# A47/A11 Thickthorn Junction

**Scheme Number: TR010037**

## **9.6 Applicant's Comments on Local Impact Reports**

**APPLICANT'S COMMENTS ON LOCAL IMPACT REPORTS**

Appendix 1: Proposed Site Layout

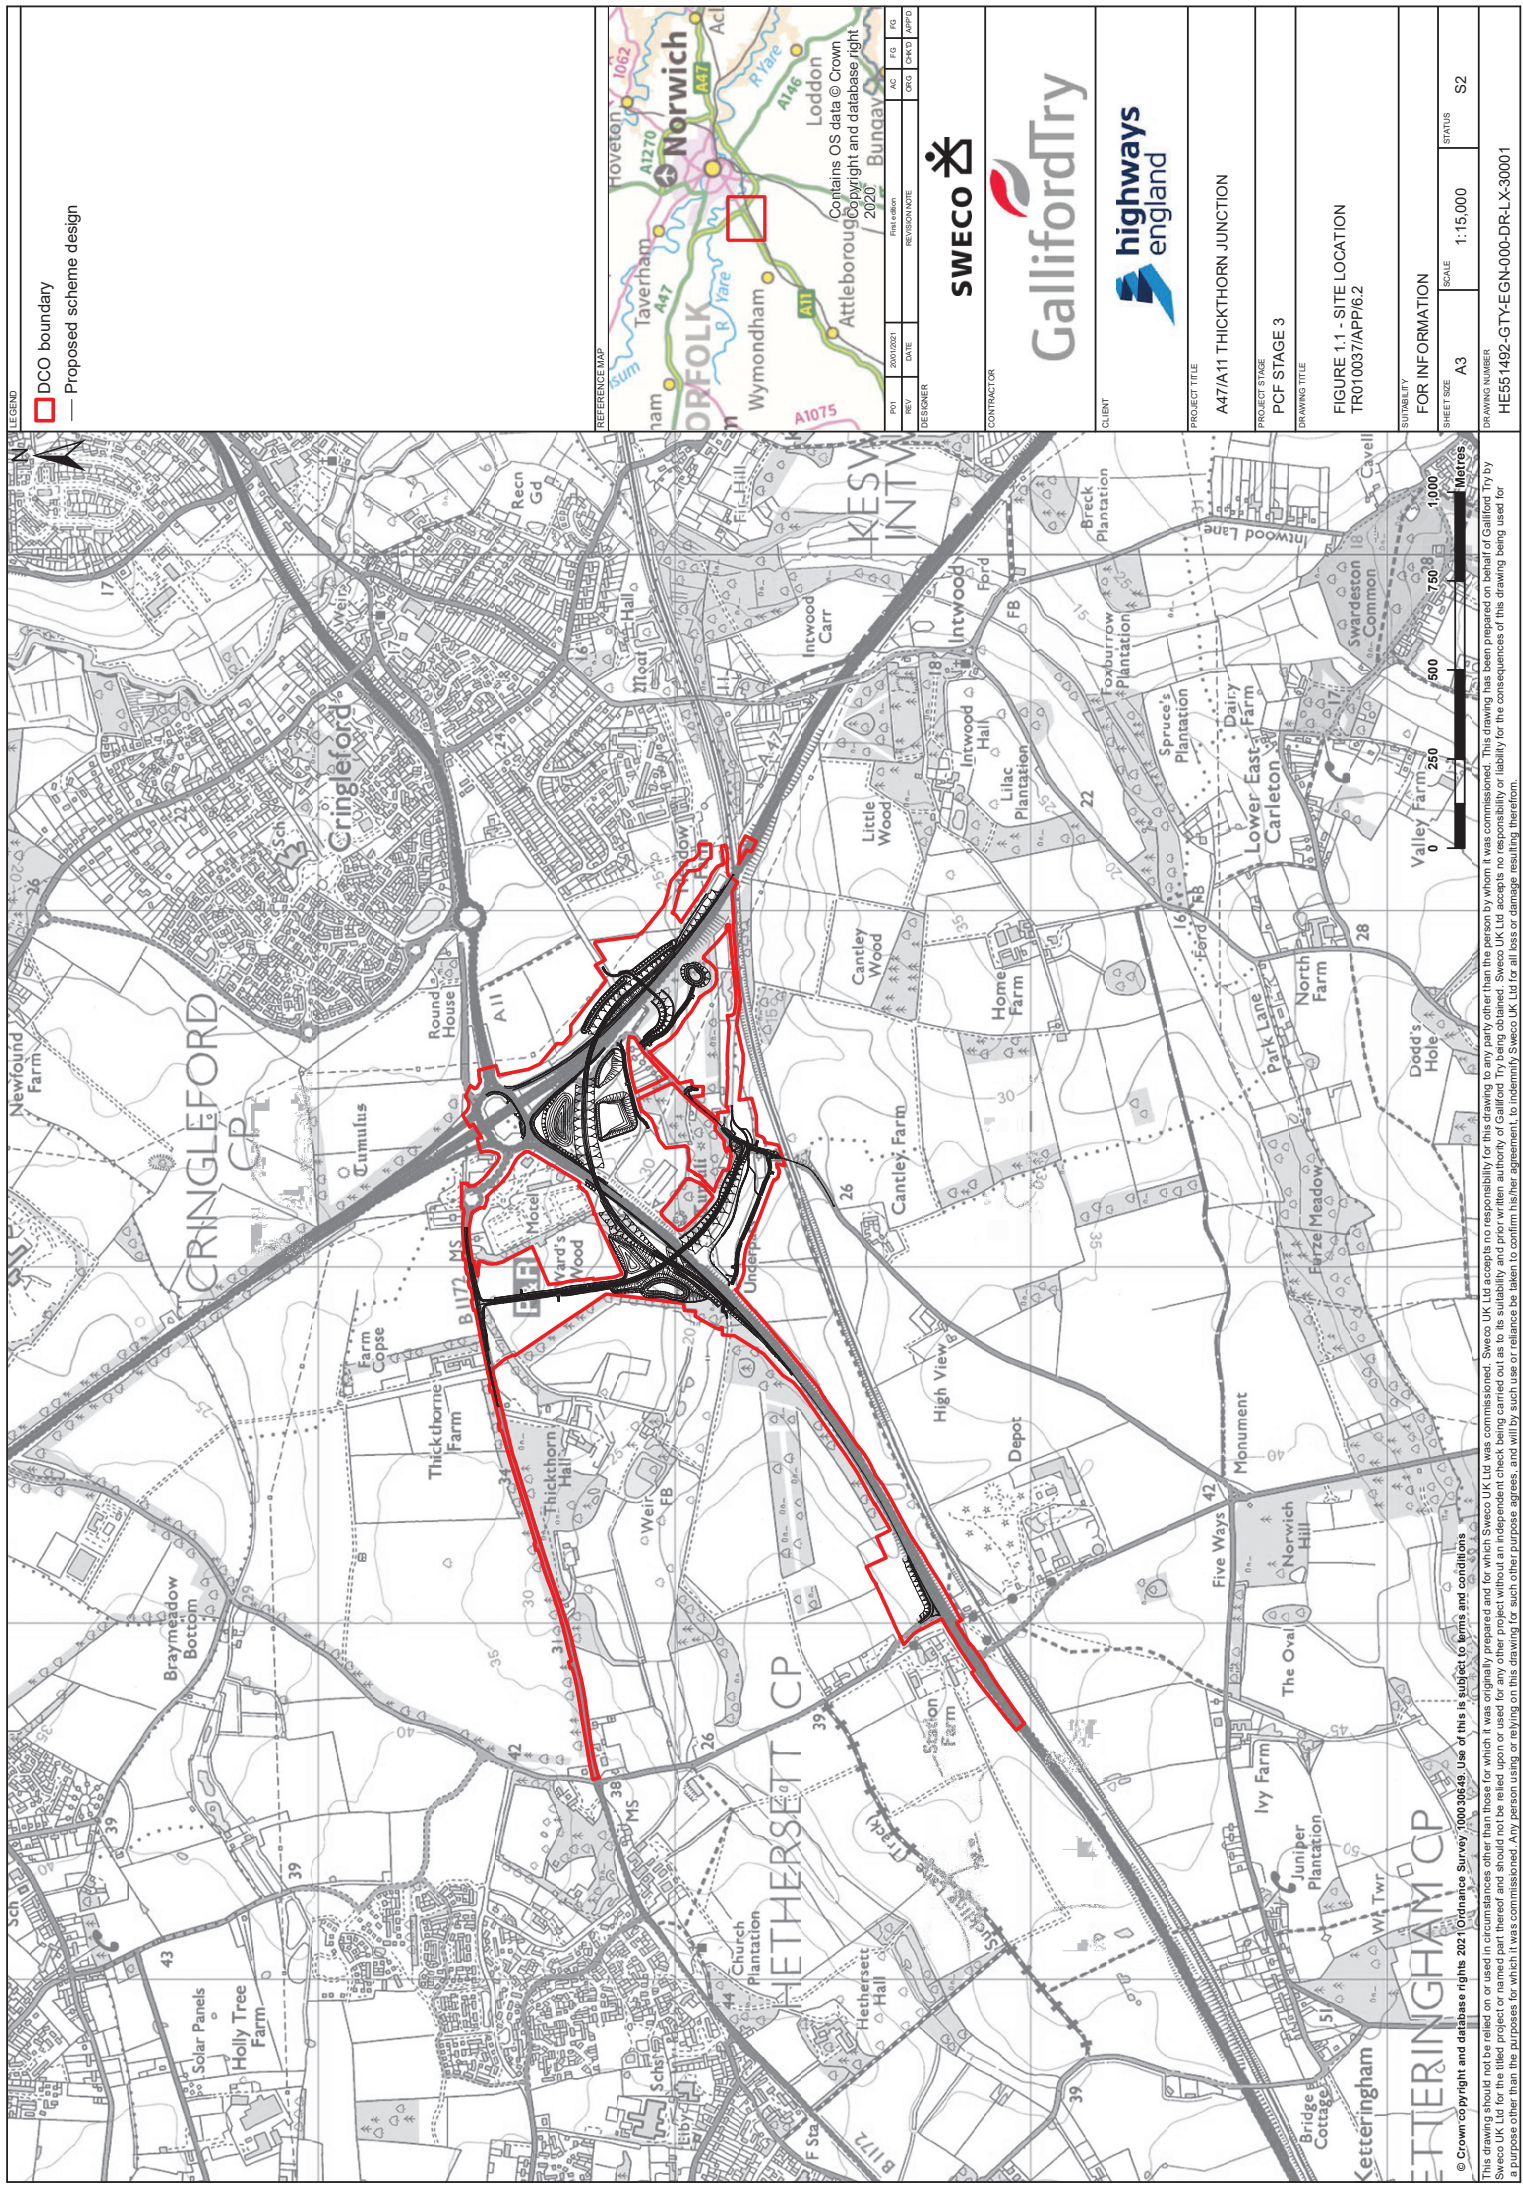
4.8.1	"The AIA has identified that a site compound is shown within the RPA of A grade trees T16, T18, T19, T20, G20, T21, T23, T25; and B grade trees T17, T24 and G26. Should this location not be subject to change, these trees will be under threat from damage such as compaction and pollution. The AIA gives guidance and methodology to avoid and reduce these impacts. Threats to the health of remaining trees have also been identified with regards to construction of fence lines, change of soil levels, installing utilities and close proximity working."	Item LV2 of Table 3-1 of the REAC contained in the environmental management plan details that an arboricultural method statement shall be prepared by an arboricultural consultant. This will include tree protection measures in compliance with BS5837:2012
